Applicant: Mrs Elizabeth Barton

Description: Erection of 1no. detached dormer bungalow with a detached single garage

Address: Land adjacent 31 Green Lane (off Tankersley Lane), Tankersley, Barnsley, S74 0DT

PROPOSED SITE LAYOUT
SCALE 1:500

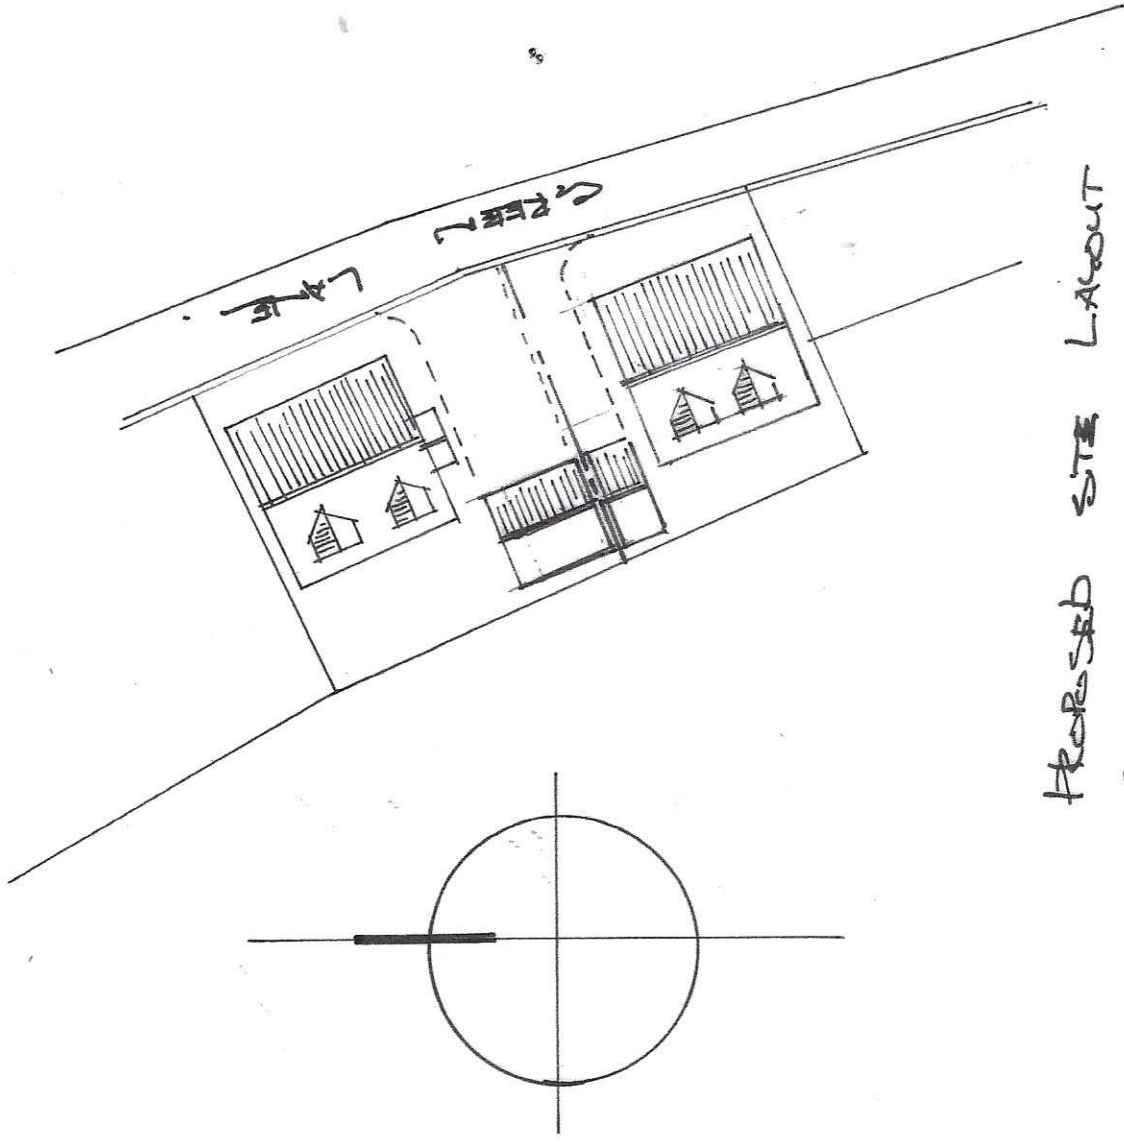
There are some discrepancies on the plans regarding the orientation of the dwelling. The proposed layout plan shows the dwelling with the dormers to the rear (West) of the site which is the case with the existing dwelling. However, the elevations plan labels the elevation with the dormer as 'Front'. In addition, the elevation with the main entrance door is labelled as 'North' elevation, which would tally with the layout drawing with the dormers to the West, but from the orientation of the floor plans the main entrance is shown on the Southern elevation.

The internal rooms of the proposed dwelling meet or exceed the requirements of the South Yorkshire Residential Design Guide, however, although the rear private amenity space just meets the 60m² requirement it only has a depth of 4.5m resulting in a wide but shallow garden area which would impact its useability as a family home, not to mention the impact on outlook from the ground floor windows with the rear elevation being so close to the rear boundary. In addition, if the Northern elevation drawing and the site layout are to be believed and the Western (rear) elevation is to contain the dormers then there is no access to the garden from that elevation which contains the dormers.

Policy H9 states that that development within the curtilage of existing larger dwellings will be resisted where it will have an adverse impact on the setting of the original dwelling, and the side of the remaining garden area. In this case the garden area of the original dwelling will be reduced by circa 335m² leaving the residents with circa 95m² of private garden area. This is a significant reduction and as with the proposed dwelling the garden would only have a modest depth compared to its width. Furthermore, the garden would be West facing rather than the existing

With regard to refuse collection, it is proposed for residents to move their bins from the proposed dwelling to the Green Lane junction with Tankersley Lane for collection. This means that residents would be expected to move their bins a distance of some 60m+ which is double the recommended maximum distance of 30m set out in Approved Document H of the Building Regulations and is therefore unacceptable.

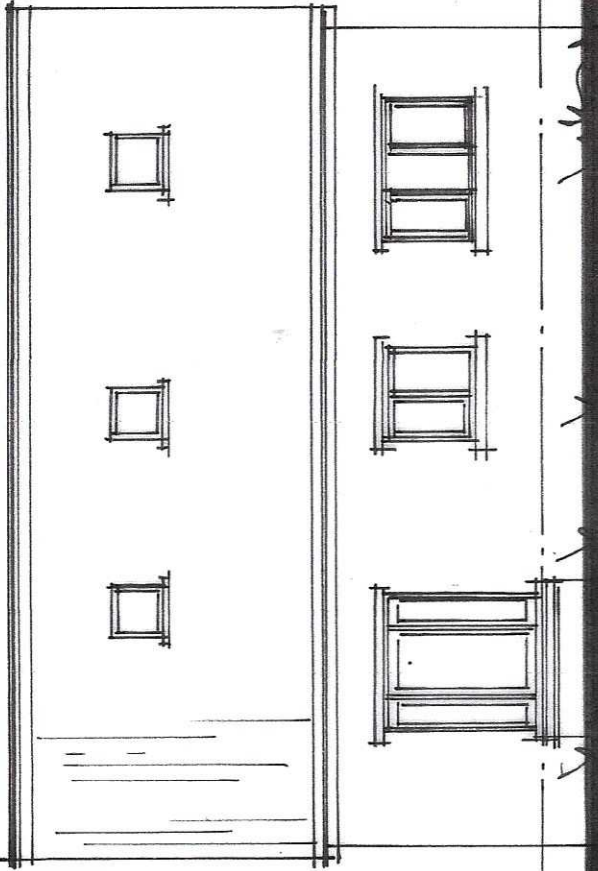
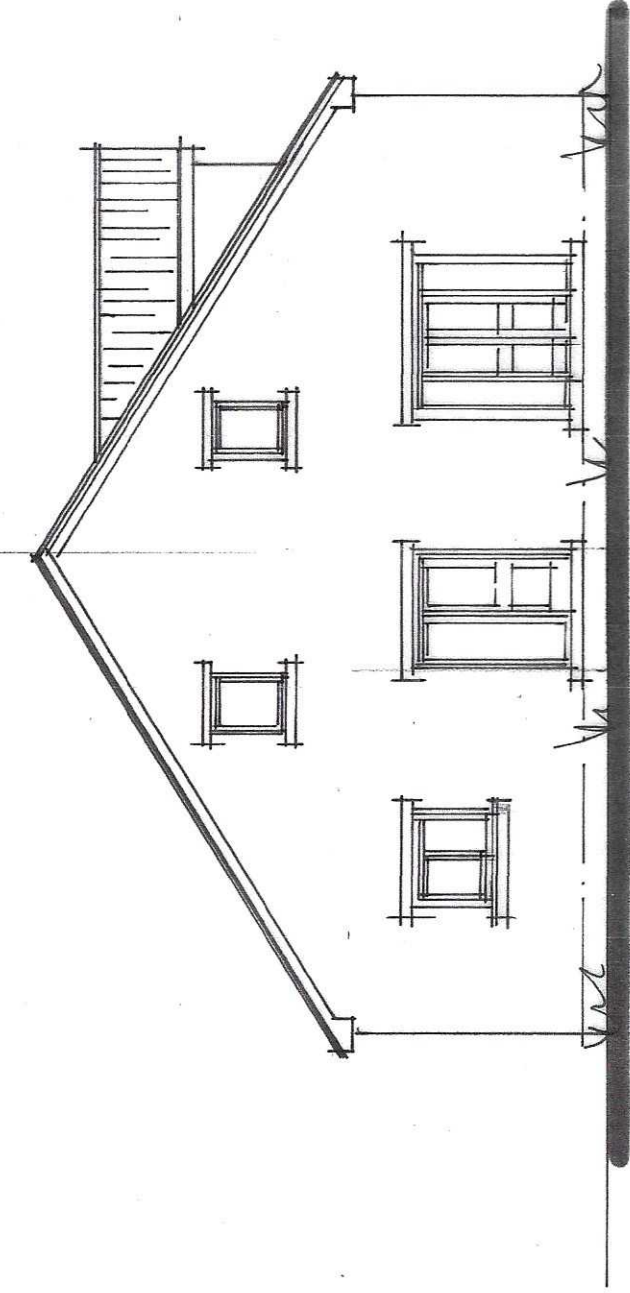
In any case, the existing dwelling has habitable room windows on the Southern elevation (which contains the main entrance to the property) and the proposed dwelling has habitable windows and the main entrance on the Northern elevation (if the elevation drawings are labelled correctly). This would result in habitable room windows facing each other at a distance of circa 14m which falls short of the required 21m, leading to overlooking and substandard levels of privacy, contrary to Local Plan Policy GD1. This would especially be the case for the proposed dwelling which would be built on a lower level.
